RE: Project: CU-14-00002

Please accept these comments related to the conditional use permit application request for the parcel located off of Naneum Road in Section 16, T18N, R19E, WM in Kittitas County, Assessors number 18-19-16051-0001.

Hanson Short Plot Amendment
13-00008, Lot 1A, SEC 18, TWP
19, RGE 16

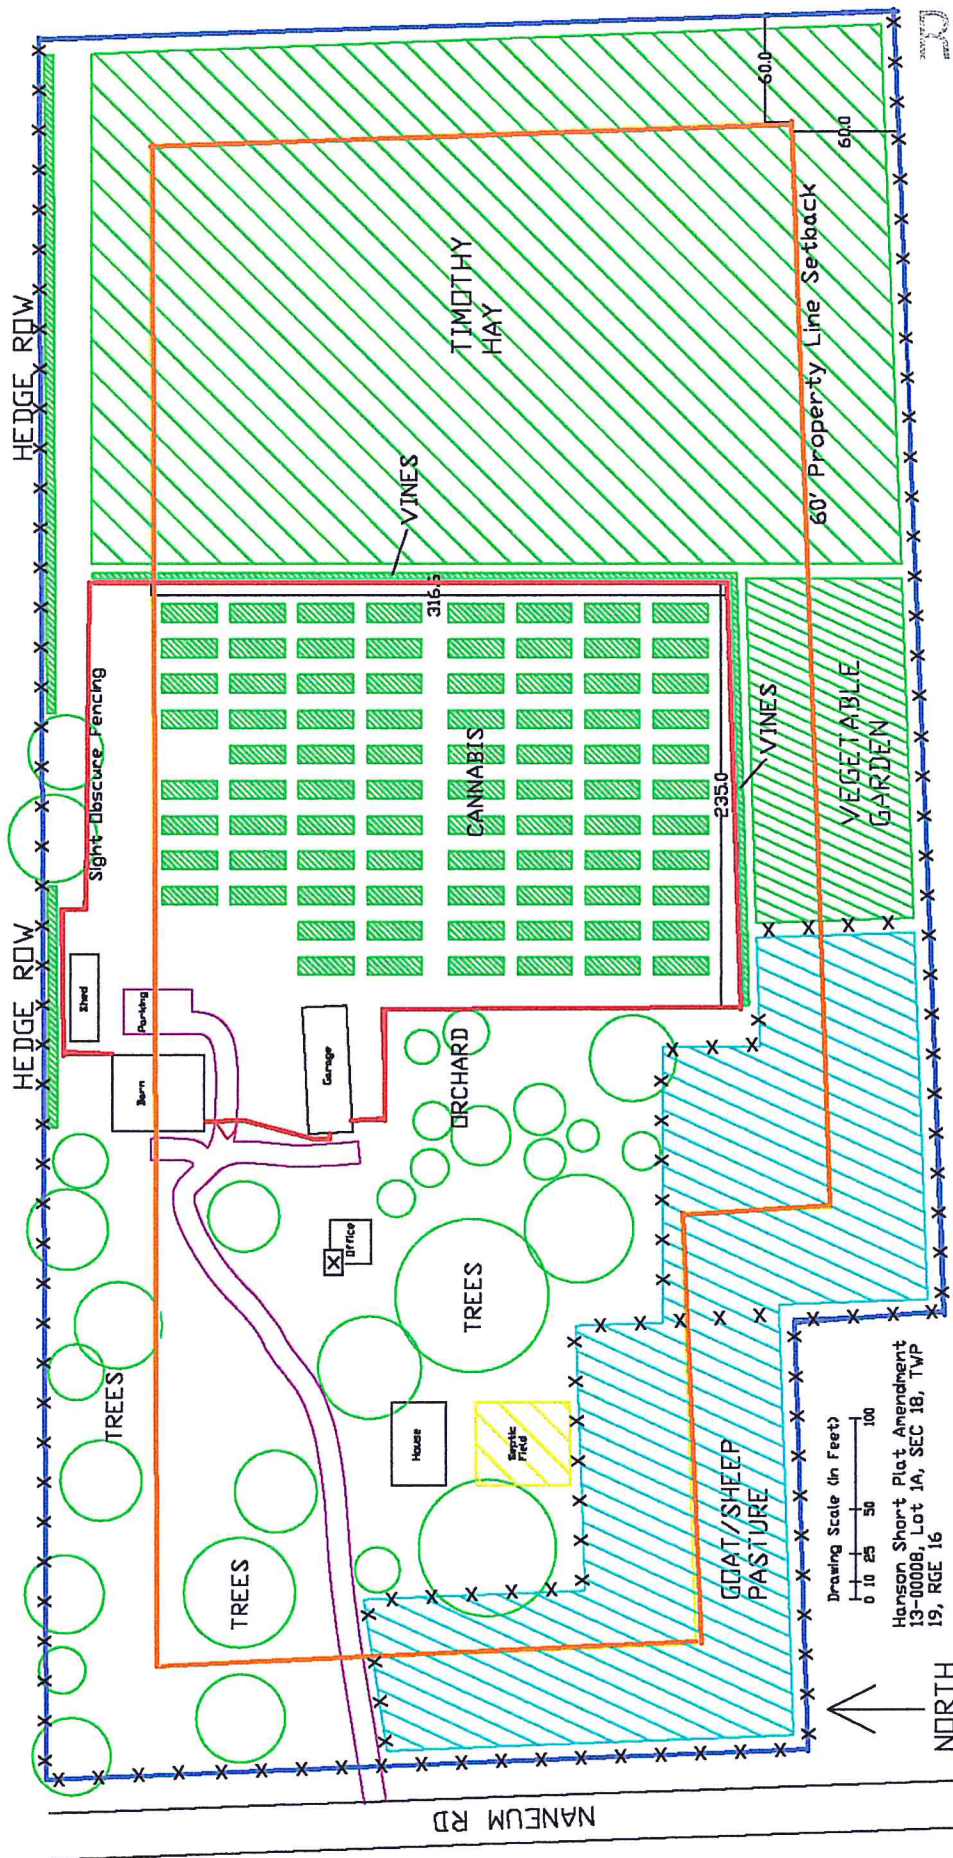
- 1) I believe that the secure fenced area, which is made up of 8 foot cyclone with slats, is not compatible with the rural area that the proposed Marijuana production is to take place. The fencing stands out and presents a negative impact where there are presently pole and barbed wire fencing.

- 2) The fencing that is required by state law is 8 feet high. This is in violation of the Kittitas County code for rural agricultural areas in the county. Has there been an application and a variance granted to exceed the 6 foot height? If not then the existing fence is in violation.
